From: Jonathan Best <Jonathan.Best@arun.gov.uk>
Sent: 19 March 2026 16:46
To: Planning.Responses <Planning.Responses@arun.gov.uk>
Cc: Hebe Smith <Hebe.Smith@arun.gov.uk>
Subject: Y/5/26/PL

2 Downview Road Yapton BN18 0HS.

I have reviewed this application with regards to ecology and Biodiversity Net Gain.

**2 Downview Road, Yapton :
Proposed Site for new Dwellinghouses :
Existing Habitats**

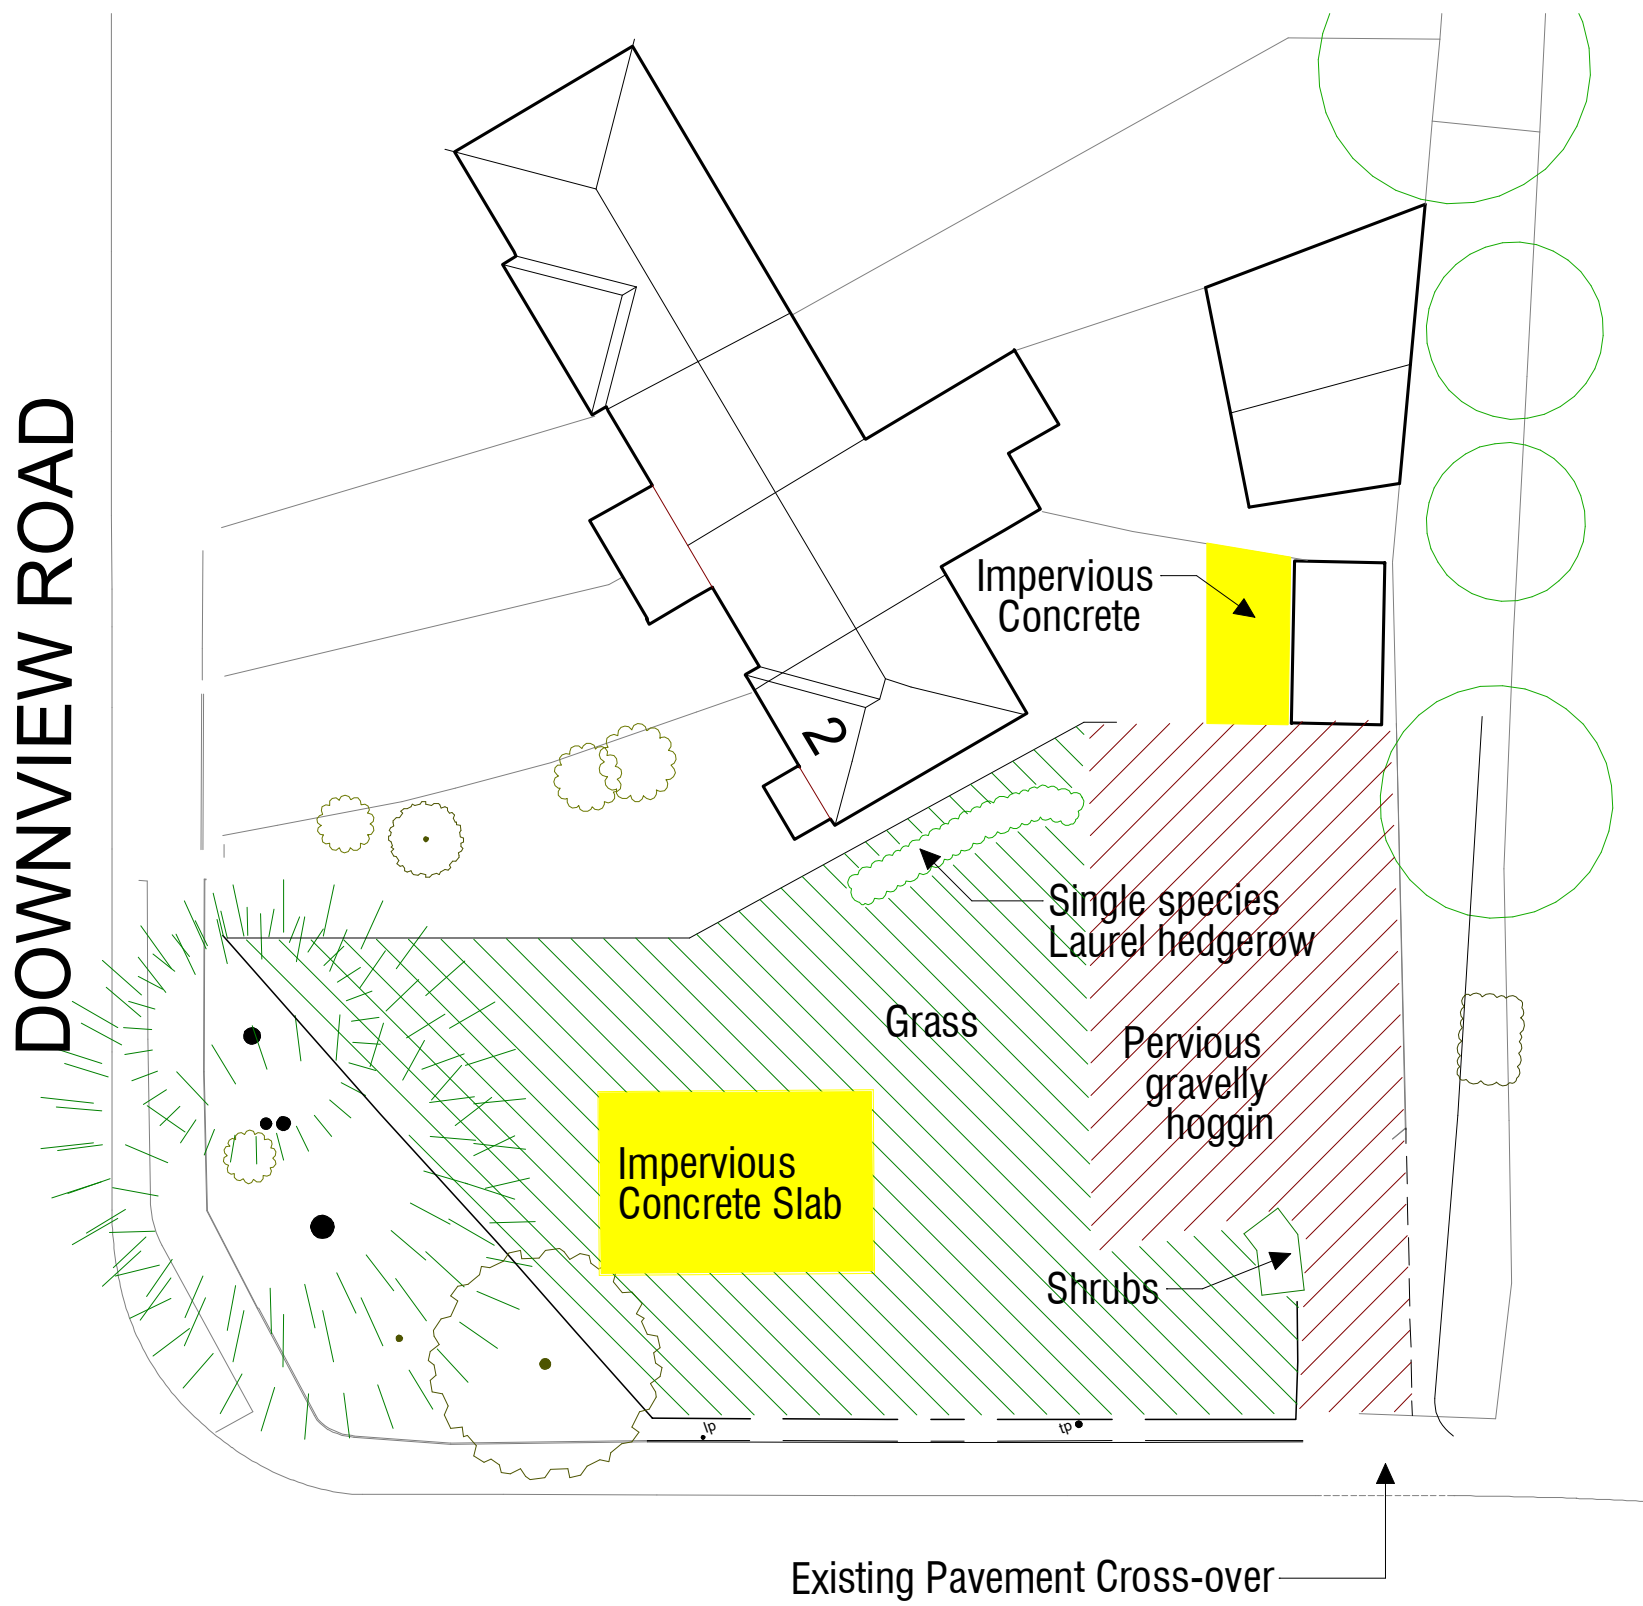
The site had a line of mature trees present in 2024 on the southern boundary, but these have since been removed. Habitat present in January 2020 should be counted even if it is no longer present. This will change the baseline for habitats and may show a loss of biodiversity units.

Figure 2. Proposed development habitat map, with additional recommendations to meet required BNG targets.

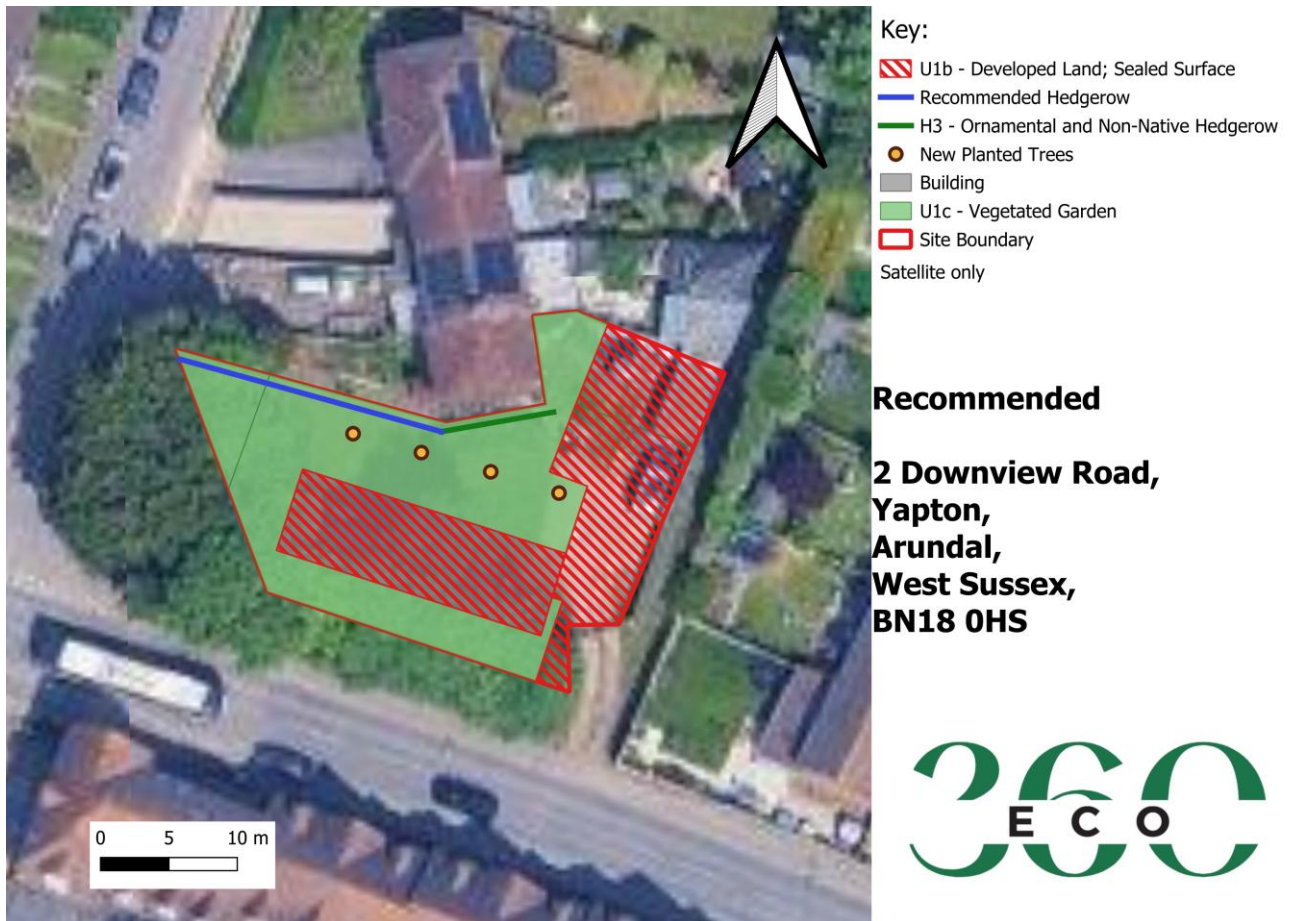
The provision of hedge and tree planting is welcomed but cannot count towards biodiversity as it is located within a private garden.

The post-development private garden has no public access, and biodiversity net gains cannot be legally secured. As these gains cannot be secured you should only record created private gardens as either:

- *‘urban – vegetated garden’; or*
- *‘urban - unvegetated garden’*

You should not:

- *record the creation of any other new habitats within private gardens*
- *record enhancement of any habitat within private gardens*

Therefore, the gains recorded are incorrect in this metric.
